Few other points RE: FW: Taco Bell at 1363 Washington Avenue, Portland, ME

TACO BELL  
 1363 WASHINGTON  
 PORTLAND, ME  
 PREPARED BY: JOHN BUJAKE  
 ACCUSERV LIGHTING & EQUIPMENT  
 877-707-7378  
 502-961-0357 FAX  
 jbujaake@accu-serv.com  
 FEBRUARY 22, 2016

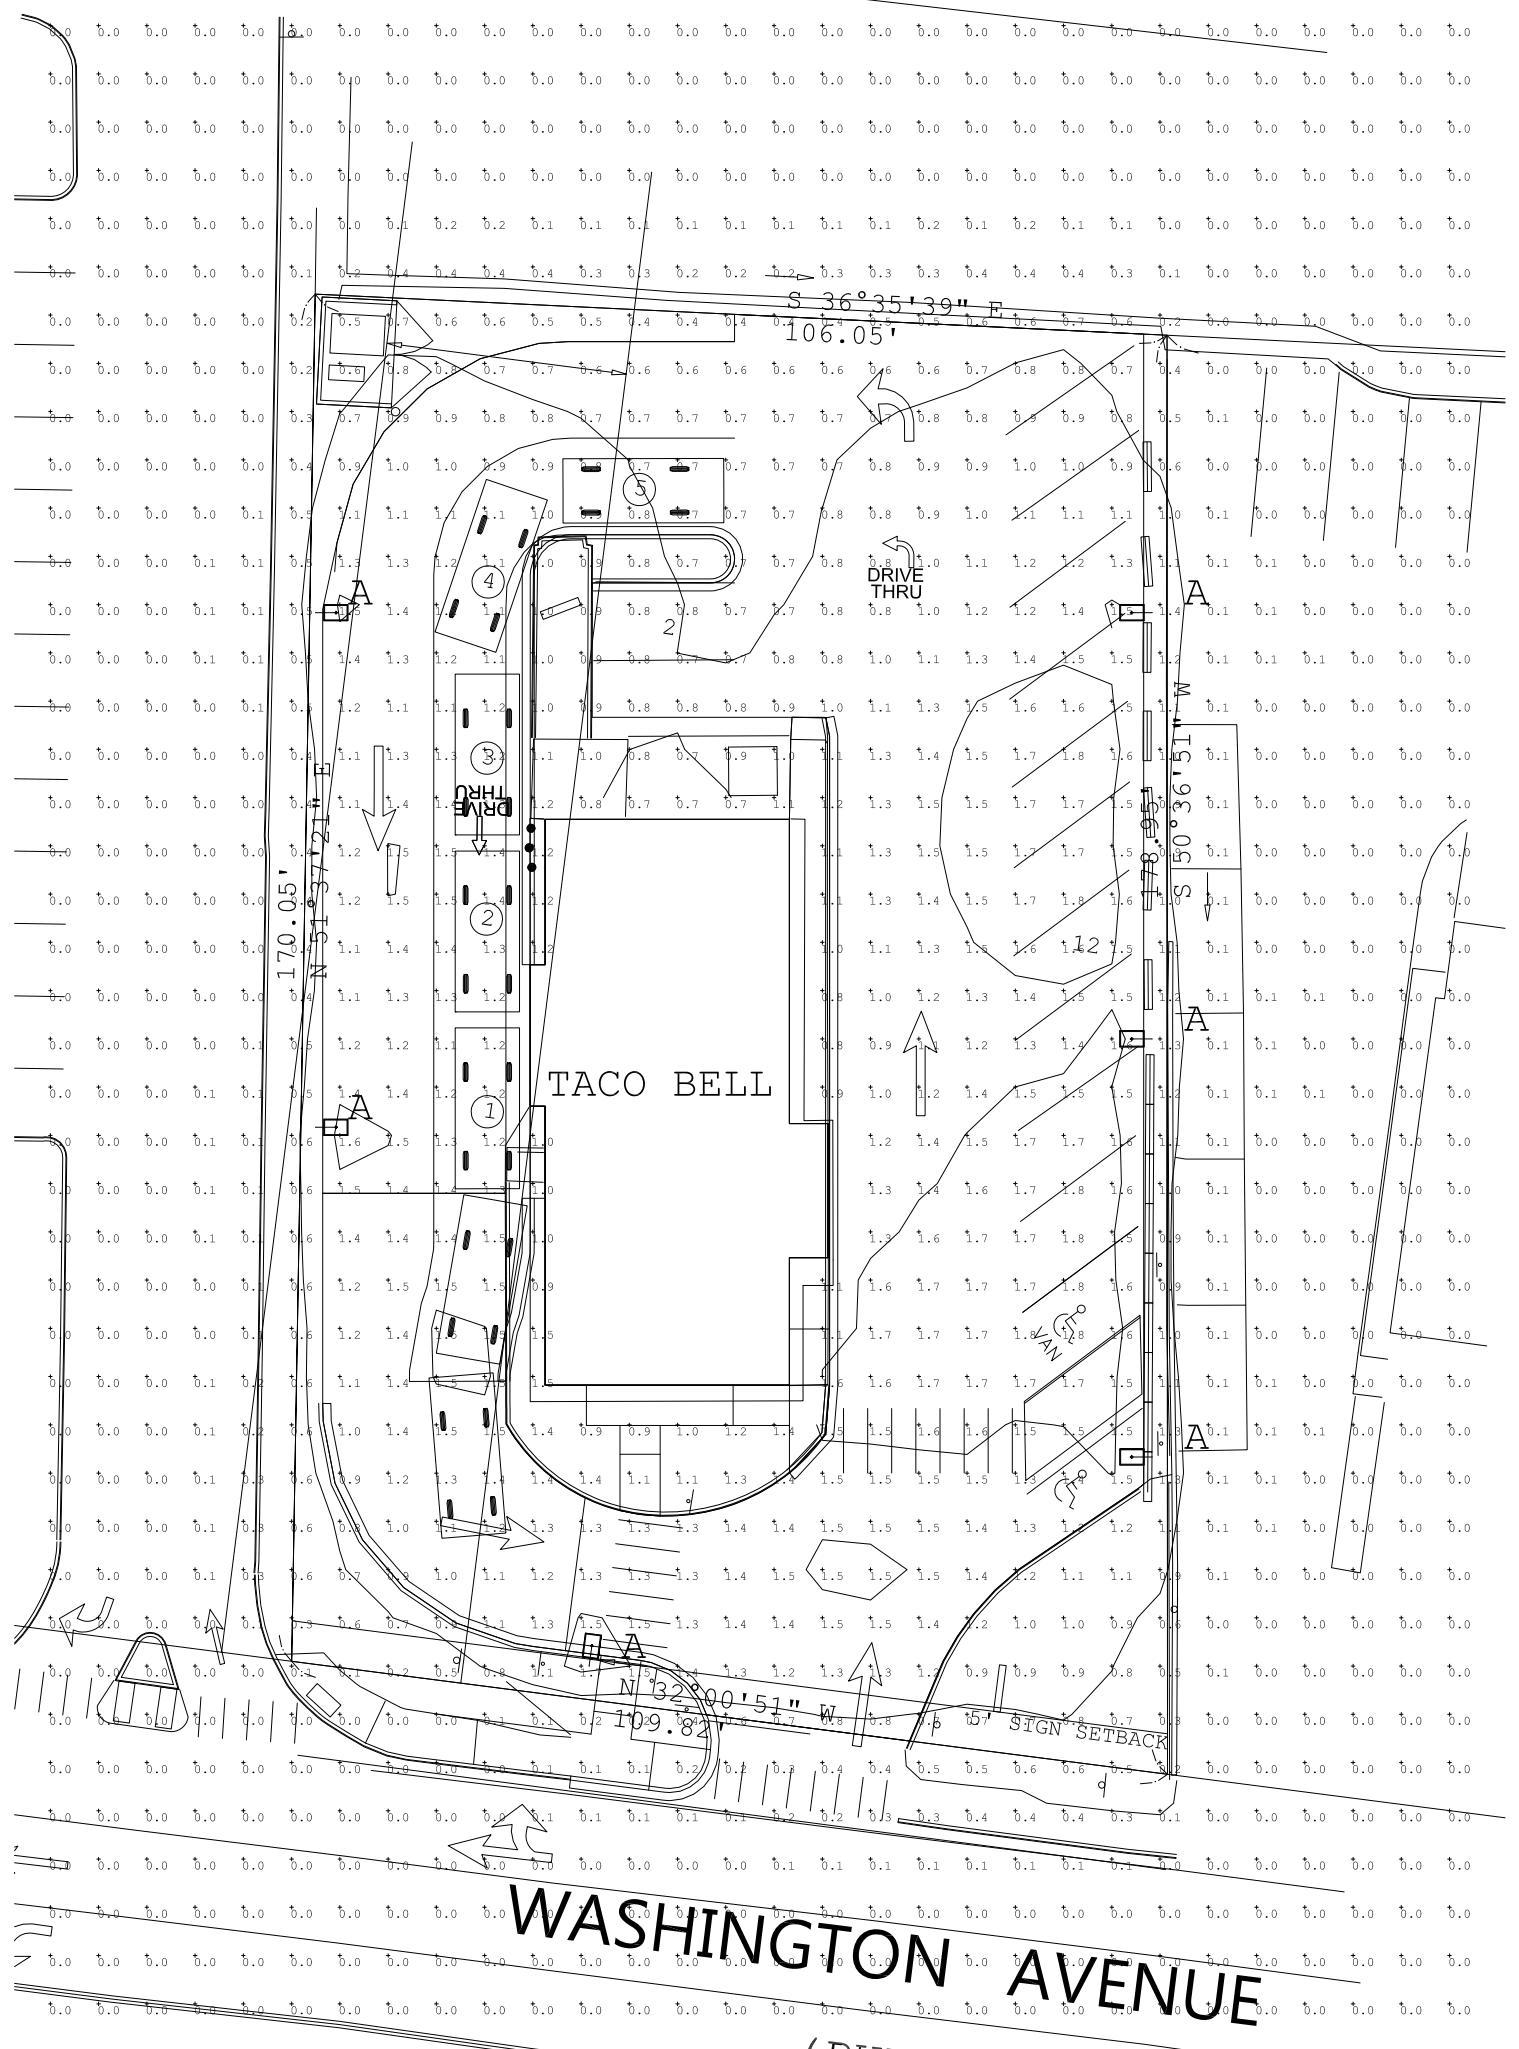
1. Per Section 4 - glass transparency: could you please send us specs and transparency information regarding the windows so we can verify. Also- are these the existing windows (retaining the with existing riser height) or have they been altered?
2. Per Section 5- materials: Could you please confirm what material the slat wall is made of (you have just specified the color);
3. Per Section 5- Lighting: We would like direct lighting (pedestrian level) over the new front door that will provide lighting for the ped crossing and entrance. The revised photometric plan should include this and be based on just the lighting from wall mounted and site light fixtures and meet the City's Site Lighting Standards which I sent previously (generally specifies a max of 5 footcandles; the proposals are well above this).
